Please ask for: Nicola Moore
Email: nicola.moore@arun.gov.uk
Telephone: Ext 37944
Our Ref: A/269/21/CLP
Your Ref:
Date: 11th January 2022

Lawful Development Certificate for a Proposed Use or Development

Development: Lawful development certificate for a proposed front porch extension and rear single storey extension and alterations
Location: 5 Ham Manor Farm Cottages West Drive Angmering BN16 4JF

Brian Heap Architectural Consultant Tel: 01905 830000 brianheaparchitect@btconnect.com		5 Ham Manor Farm Cottages West Drive Angmering BN16 4JF	
Floor Plans as Existing		December 2021	
Drawing No. 21-20114-01 A		1:50 at A3

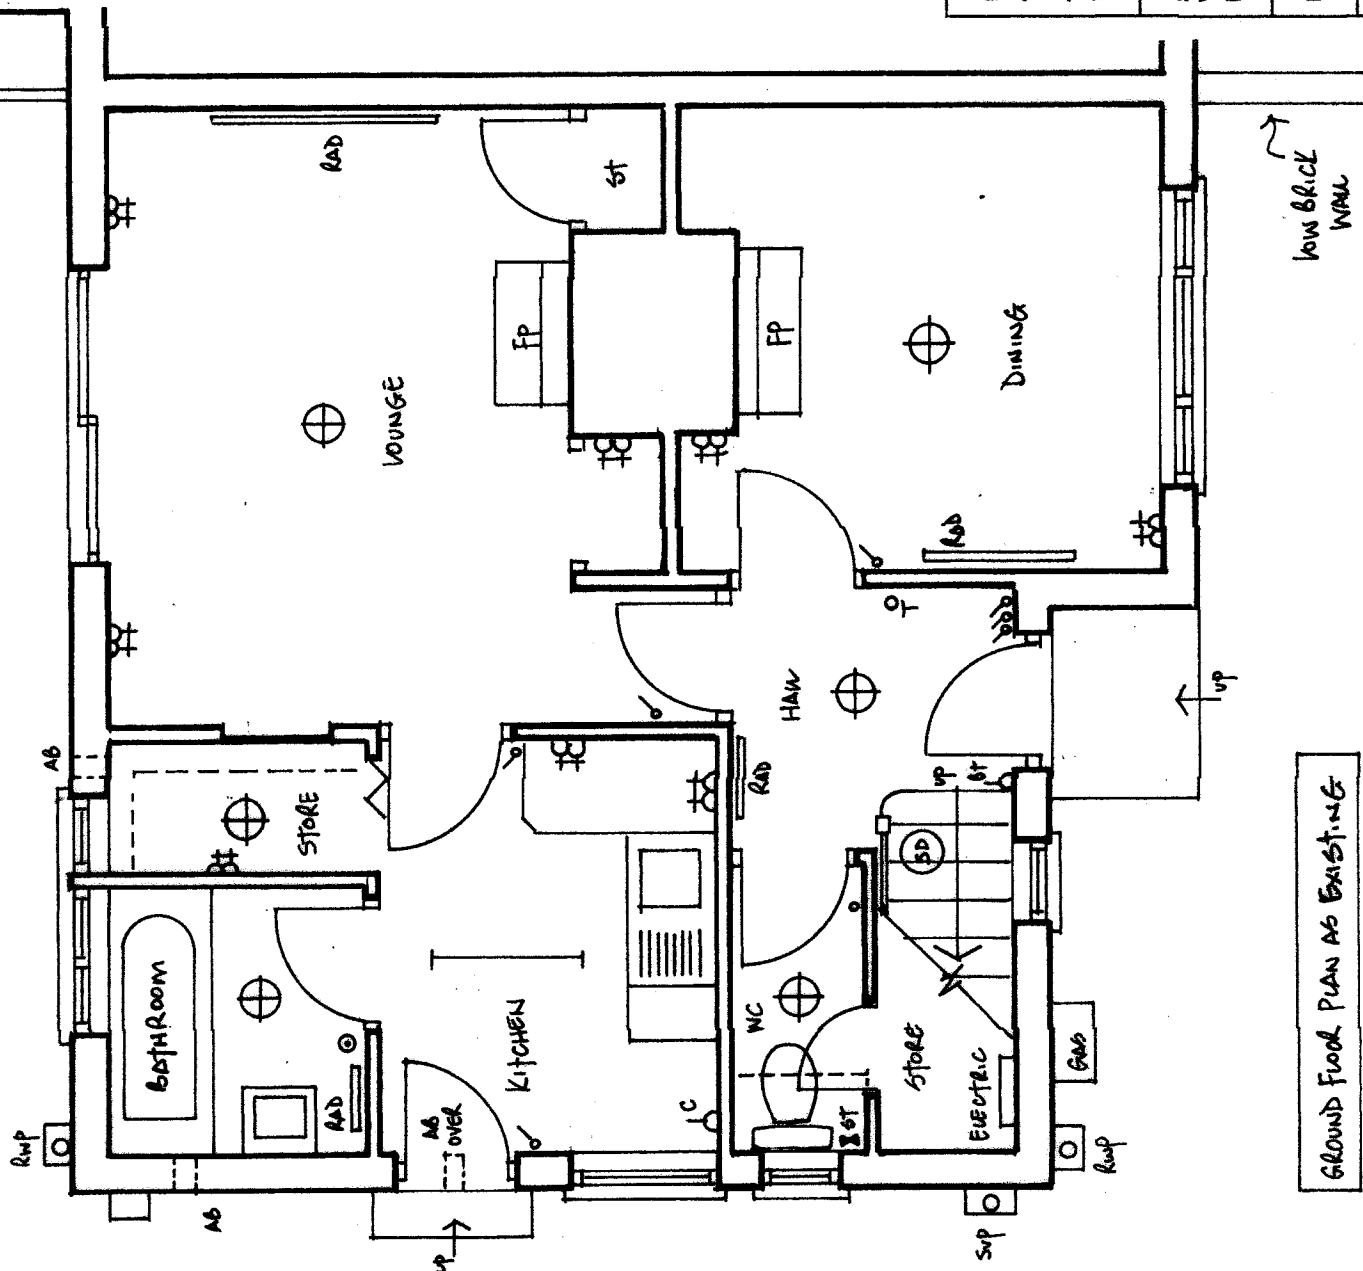
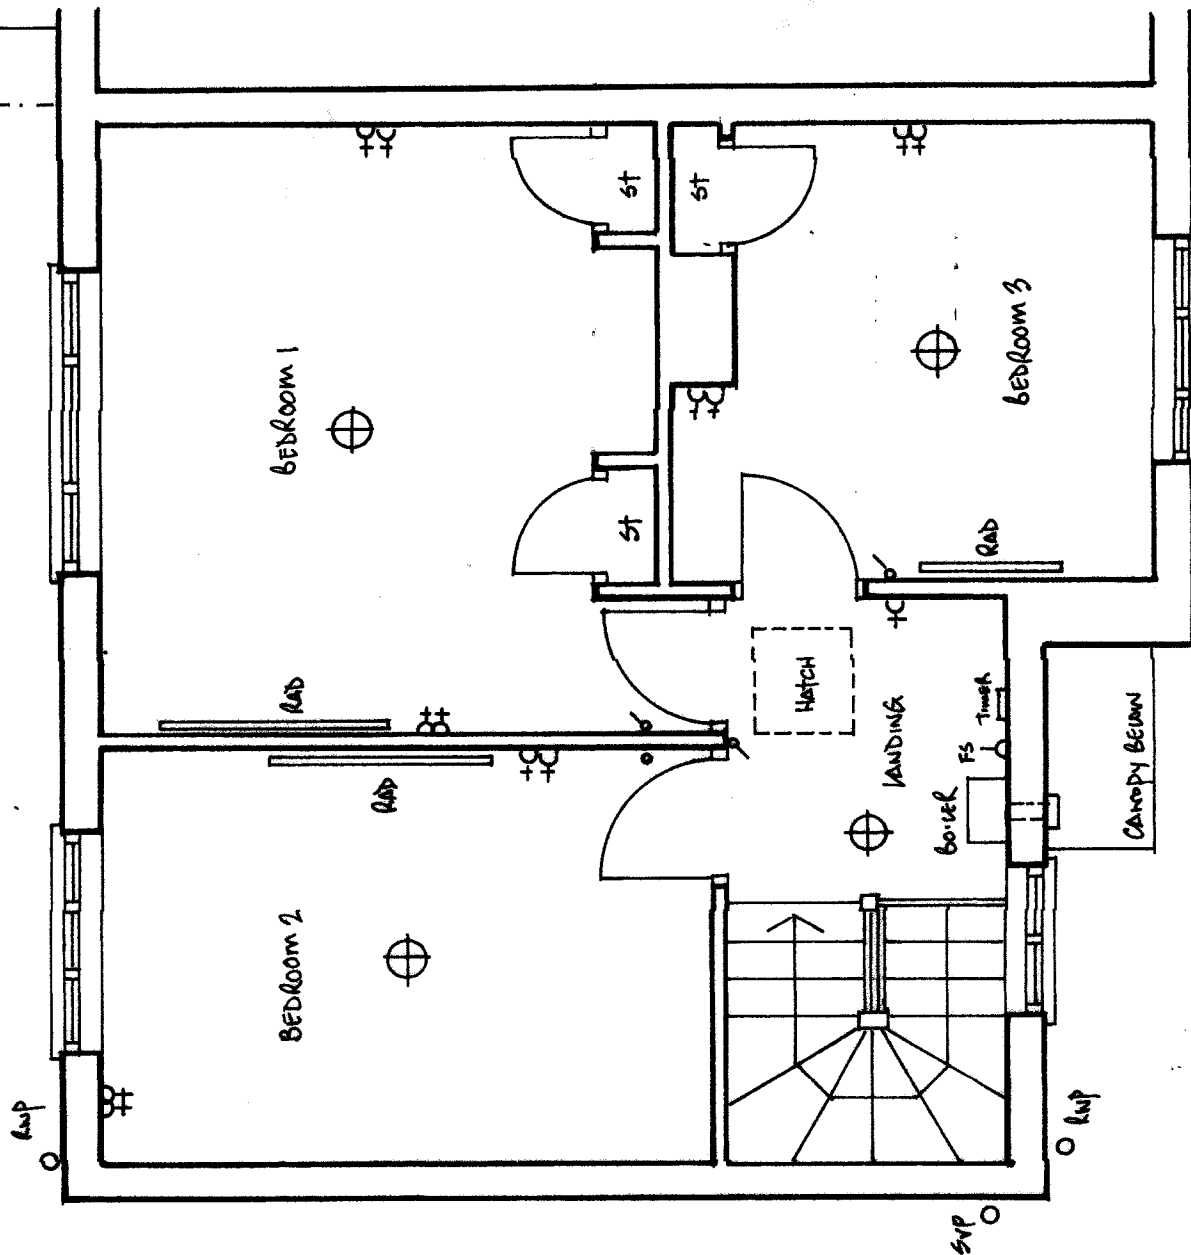
Dwg No 21-20114-01 is titled Floor Plans as Existing but the drawings are labelled as Existing First Floor and Proposed Ground Floor. Please amend accordingly and re submit.
